**Albuquerque RV and Boat Storage
Ladera Enterprises, LLC
3200 Calle De Laura NW
Albuquerque NM 87104
(505) 304-4516**

Re: Administrative Amendment to Site Development Plan
2201 Vista Oriente NW, Albuquerque, NM

Purpose of Administrative Amendment:

1
AS-101

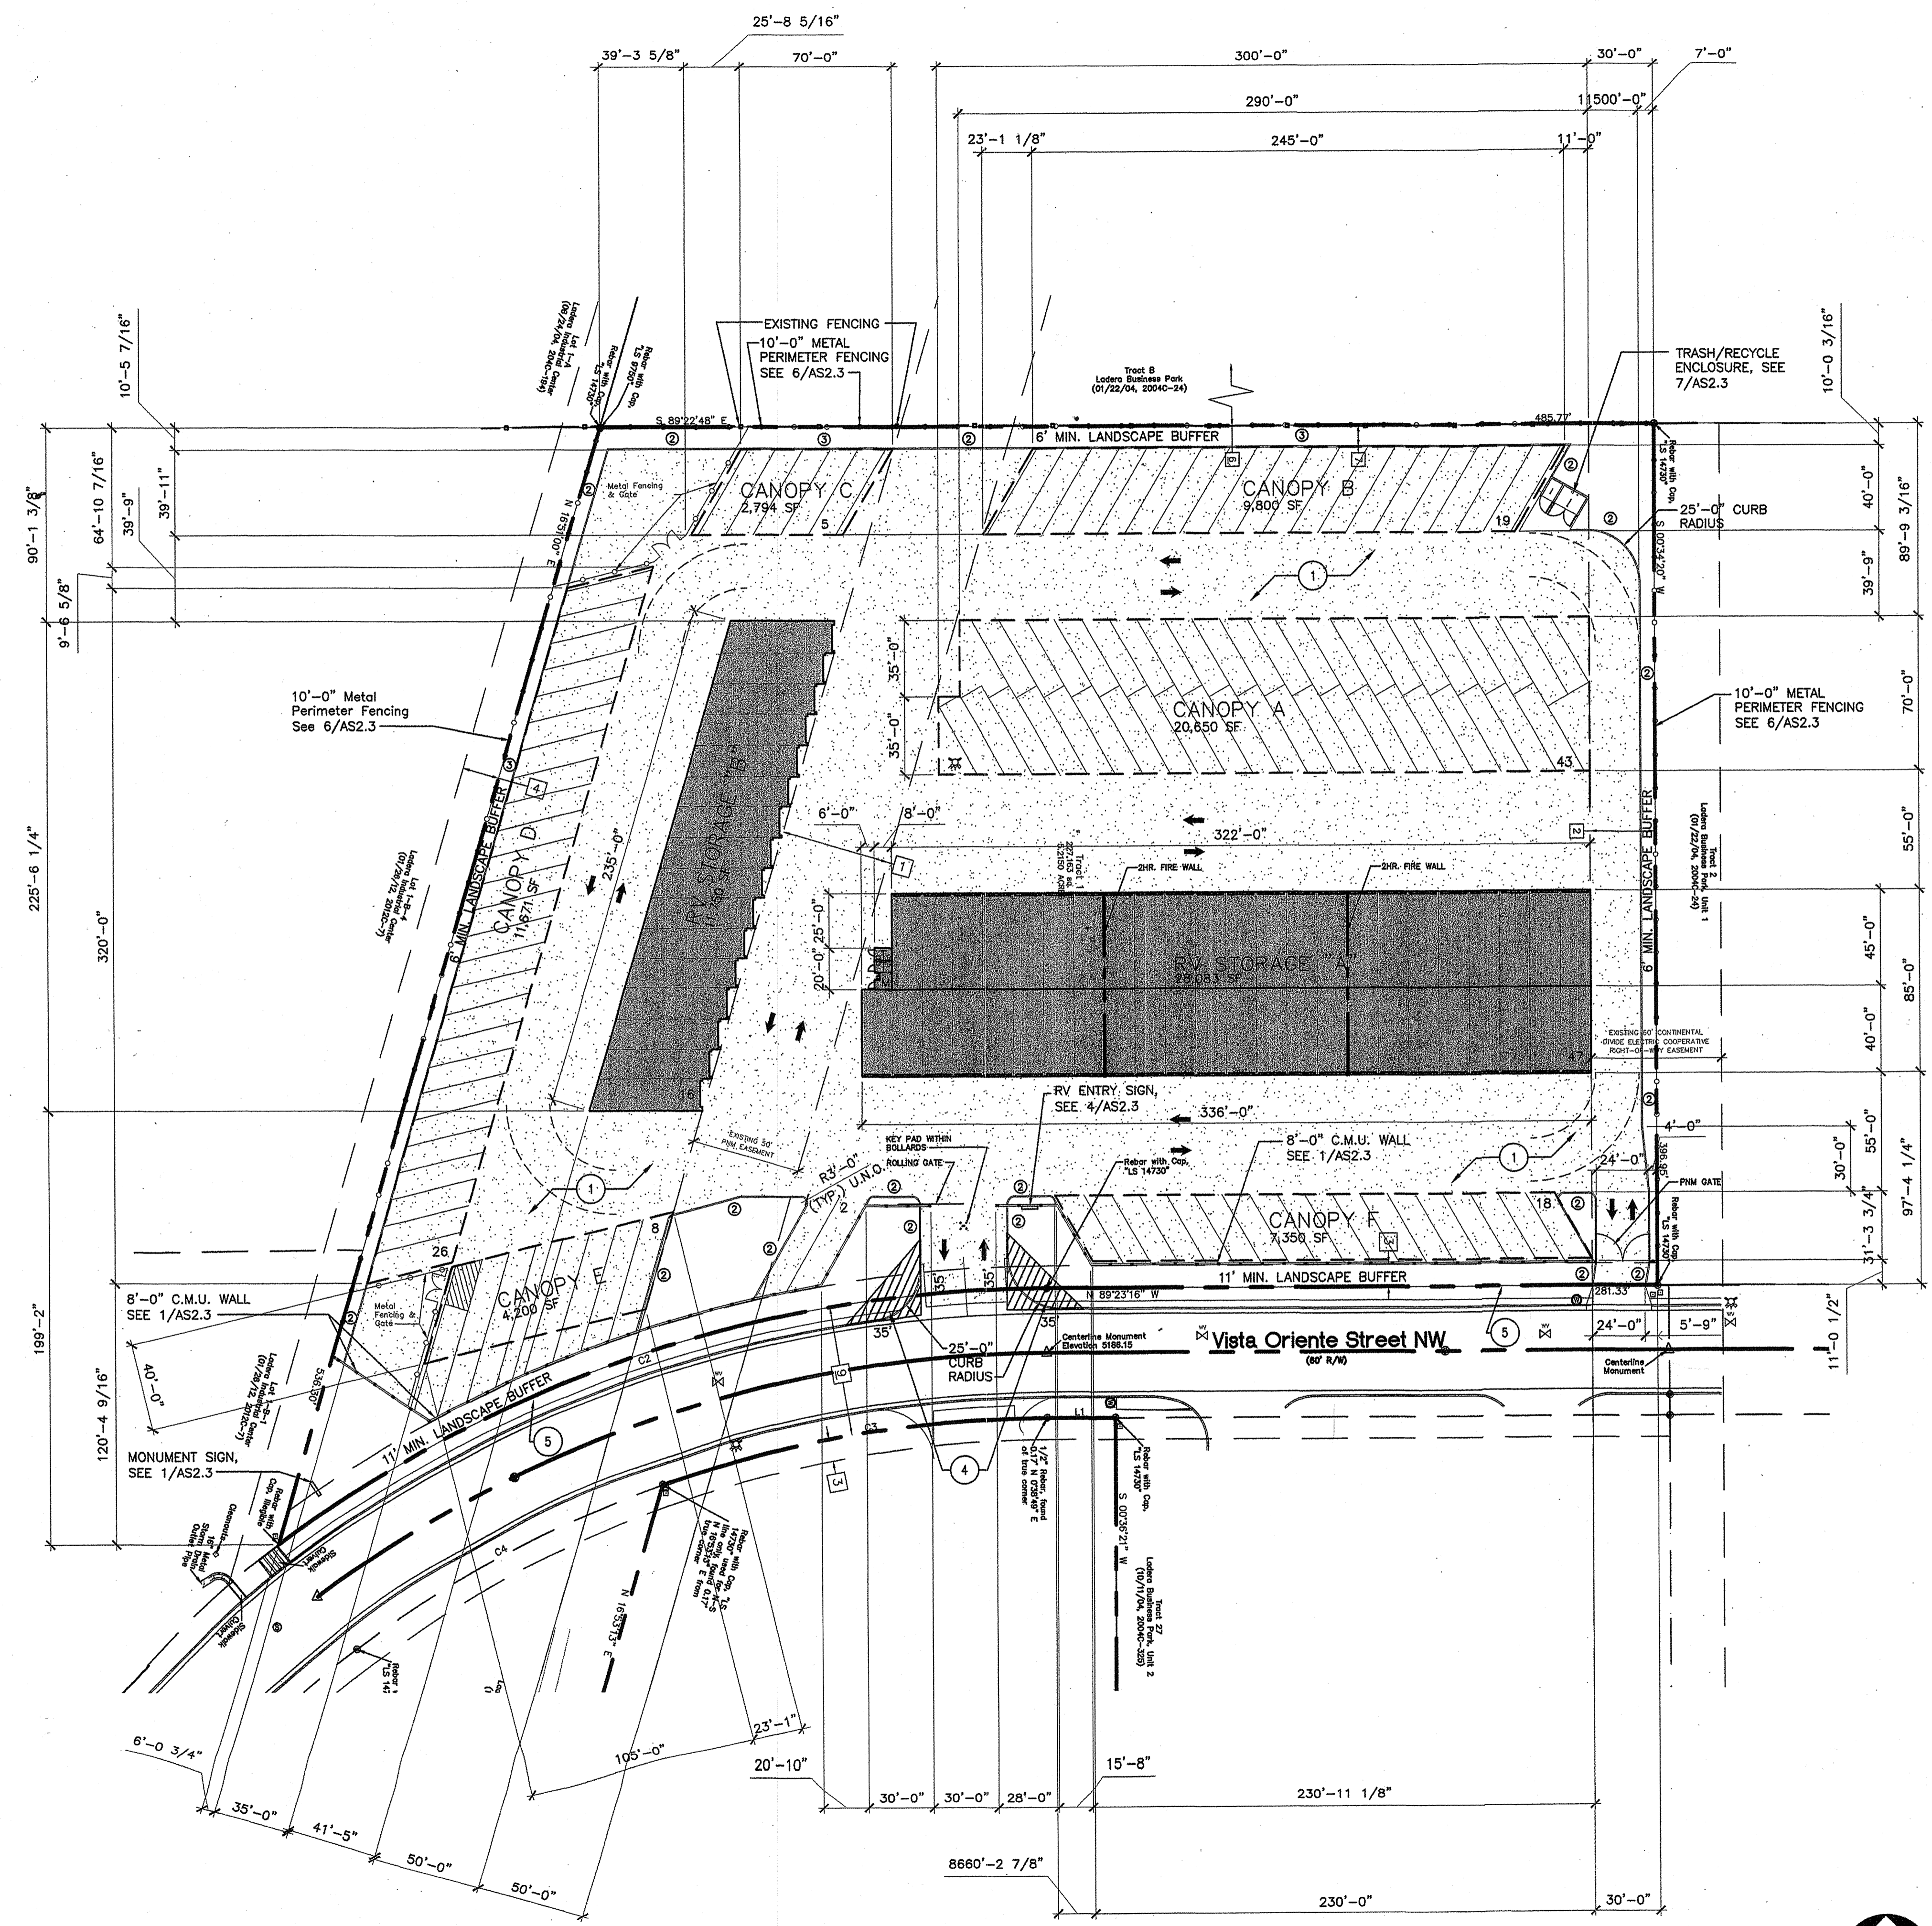
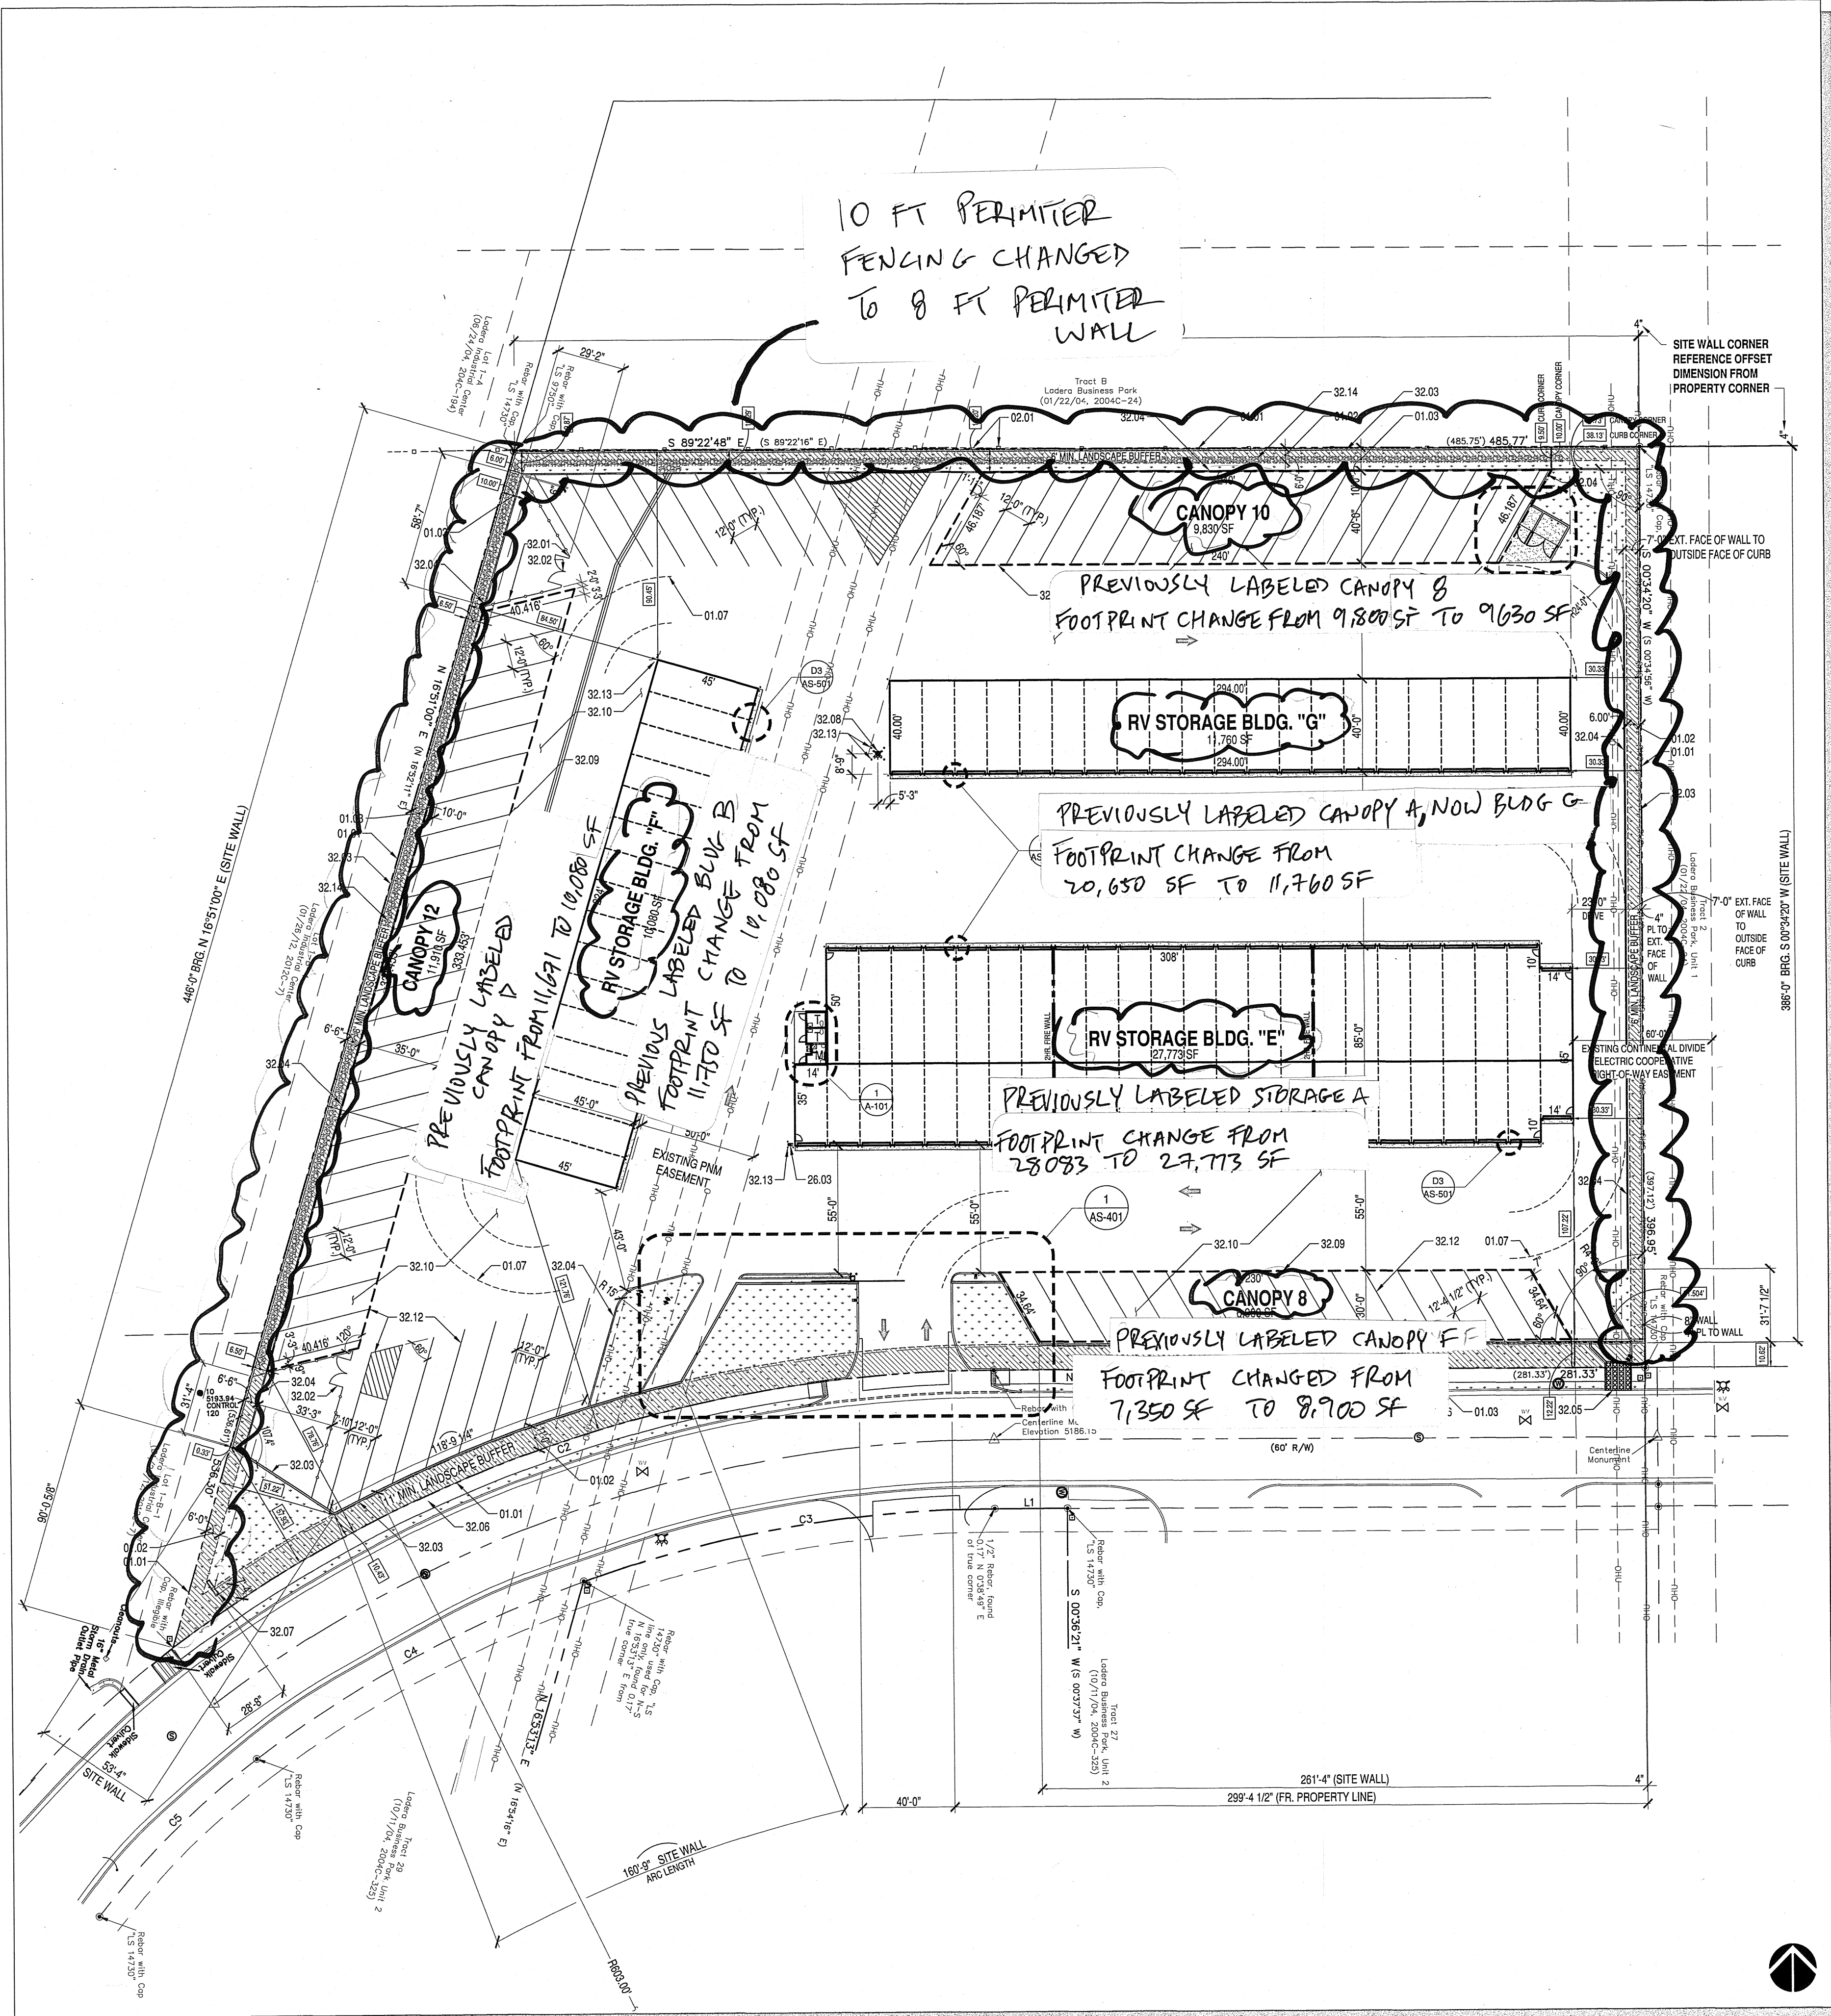
- 1) Perimeter fencing on East, North and West sides of property are now shown as 8 foot CMU wall, as per development guidelines of original site development plan project #1001523. This change will match the construction document submittal plans.
- 2) Names of the structures have been changed and square footages are revised from what is on the DRB site plan so information is consistent with construction submittal plans.
